Charlotte Department of Transportation

Memorandum

Subject: Rezoning Petition 08-067: Located on the east side of Colwick Road
between Chiswick Road and Greenwich Road

TITLE:
CONCEPTUAL SITE PLAN

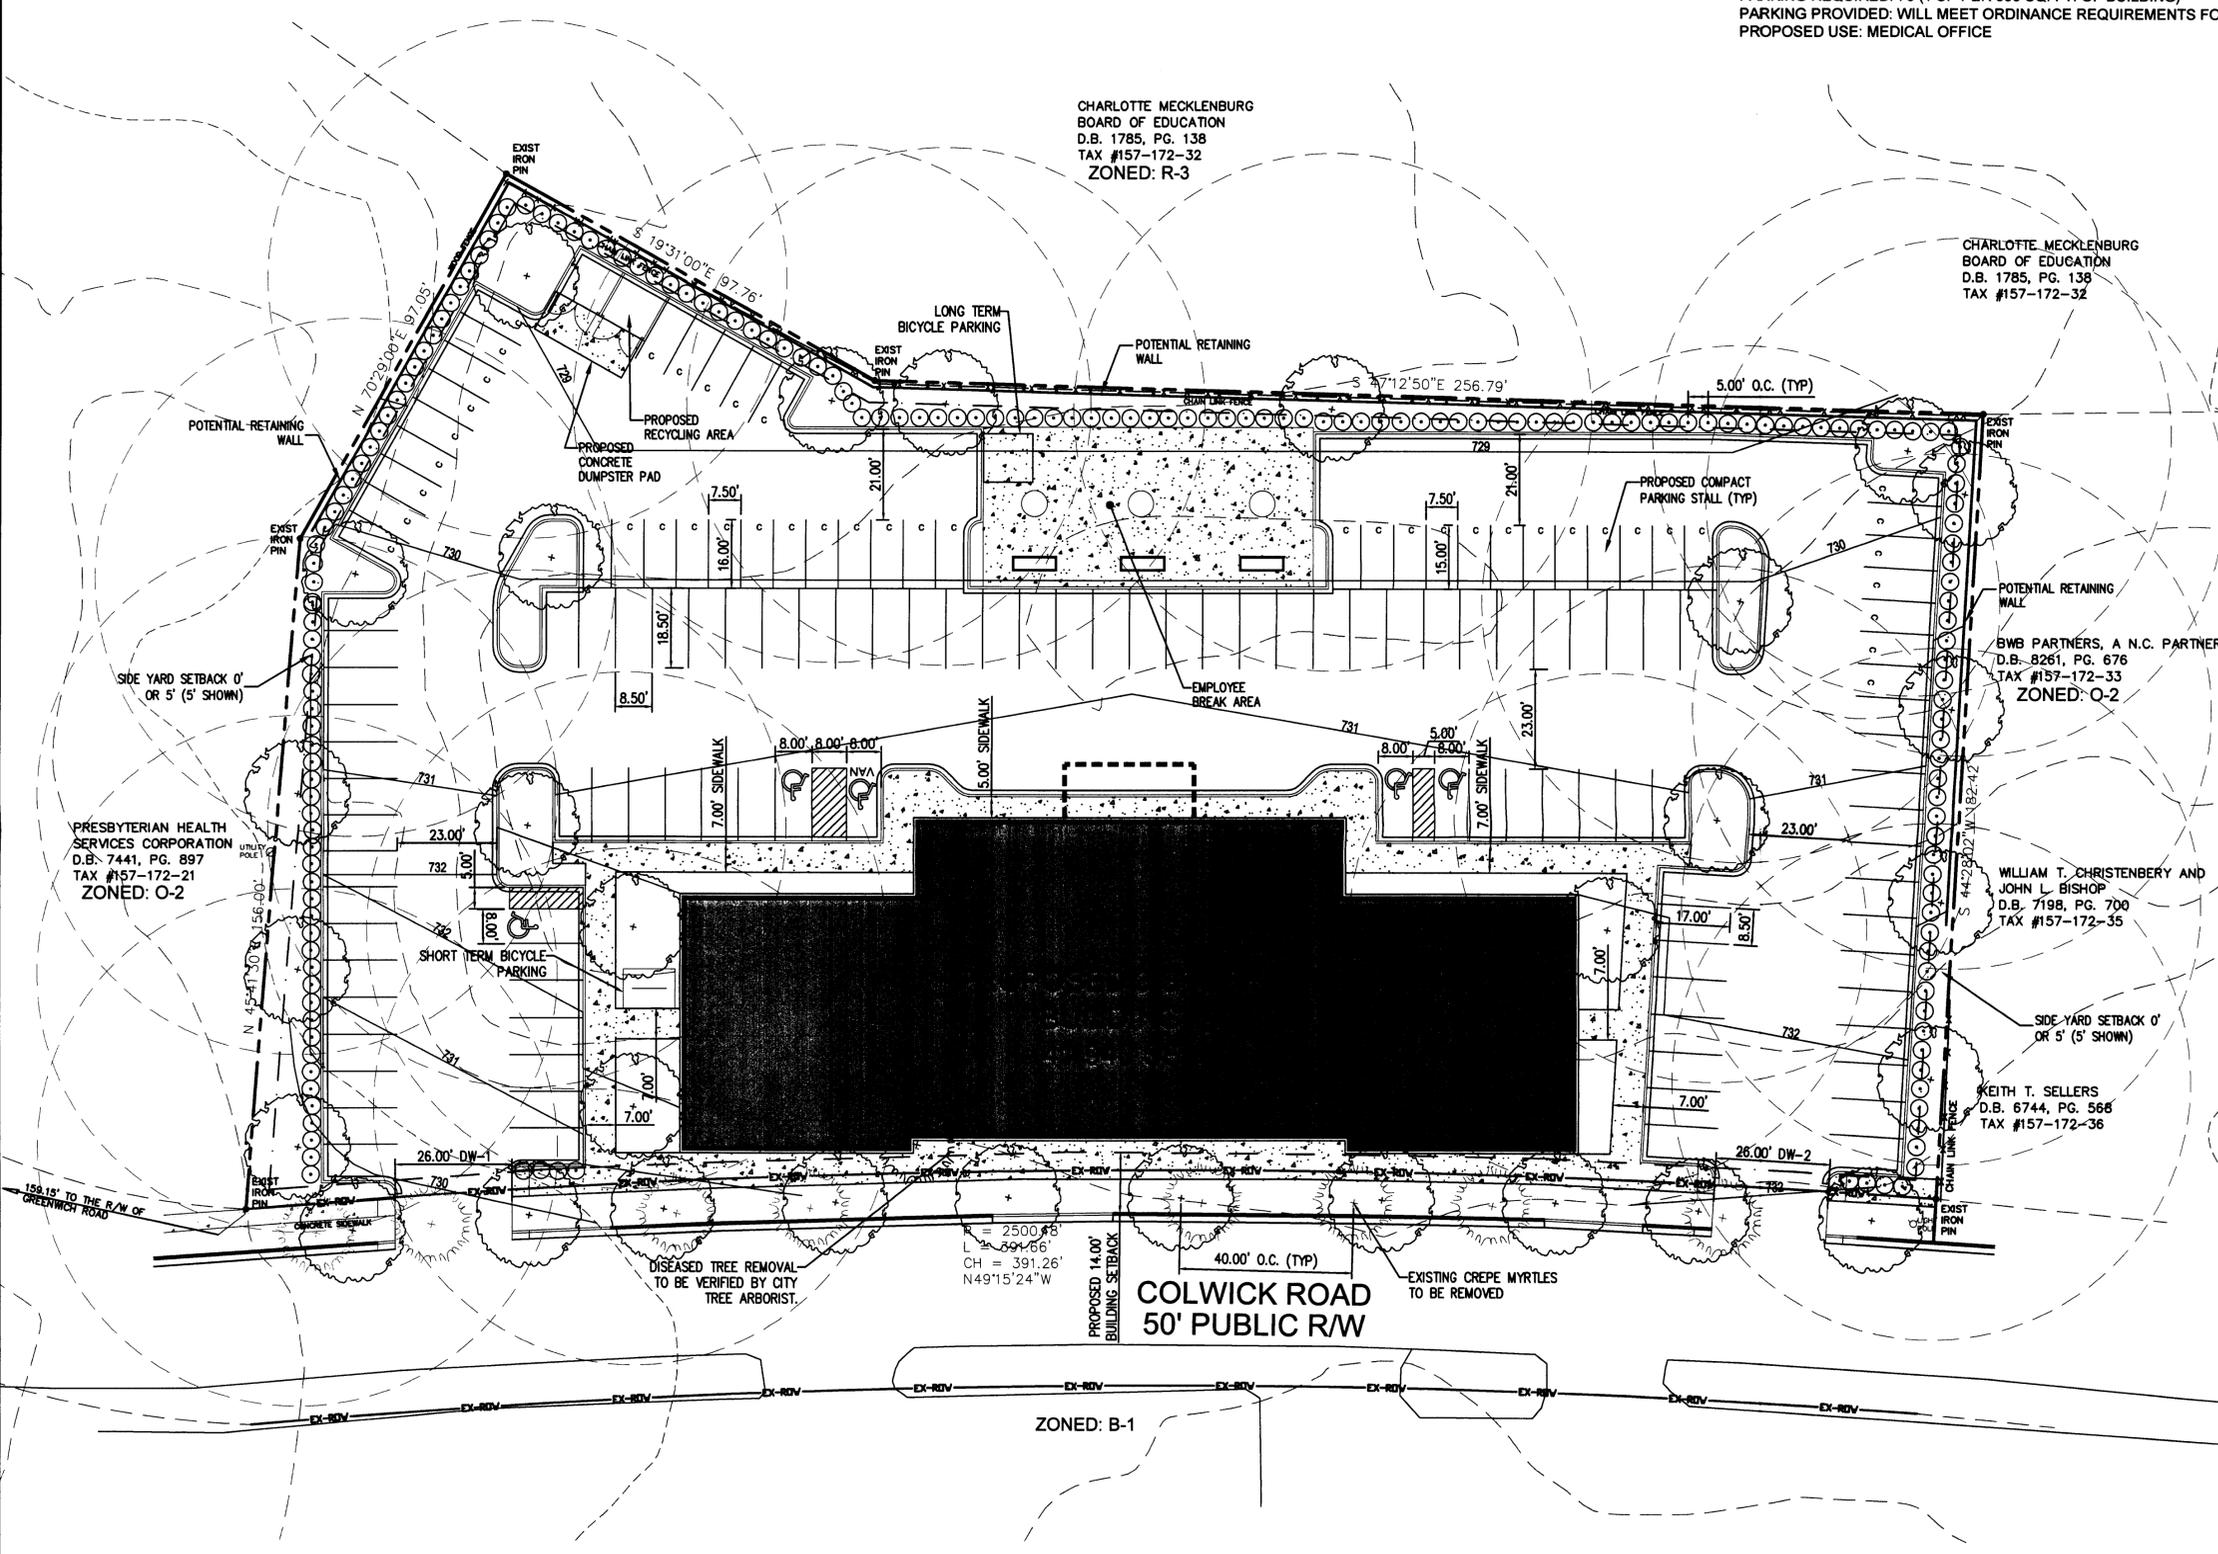
1. According to the adopted Urban Street Design Guidelines (USDG), the preferred/typical block spacing in designated Centers is 500 feet. The current intersection spacing on Colwick Road between Chiswick Road and Greenwich Road is approximately 800 feet. Although we do not believe that a new public street is needed at this particular location to provide better vehicular connectivity, we do think that a pedestrian/bike path connection is needed to provide better access to Cotswold Elementary School for students accessing the school from North Sharon Amity Road. This pedestrian/bicycle connection would help to separate students/bicyclists from the only vehicular entrance to the school via Greenwich Road. We request that the petitioner/developer contact CMS concerning the connection, provide a 10-

foot easement, and construct a 10-foot concrete pedestrian/bicycle path to Cotswold Elementary School at a location that is mutually acceptable.

2. The setback in the MUDD zoning district is measured from the back of either an existing or proposed curbline. The setback on Colwick Road is to be measured from the back of a future curbline, measured 20.5 feet from the centerline of the roadway.

1. We request that recessed on-street parking be provided on Colwick Road.

To facilitate building permit/driveway permit review and approval, the site plan must be revised to include the following:

- Dimension width of the existing and proposed driveways.
- New/reconstructed driveways must be drop curb ramp Type II-modified driveways with 8-foot radii.
- Indicate the locations and widths of all adjacent and opposing driveways.
- Indicate typical parking module dimensions.

- Include a parking summary with figures for the numbers of parking spaces required and provided.
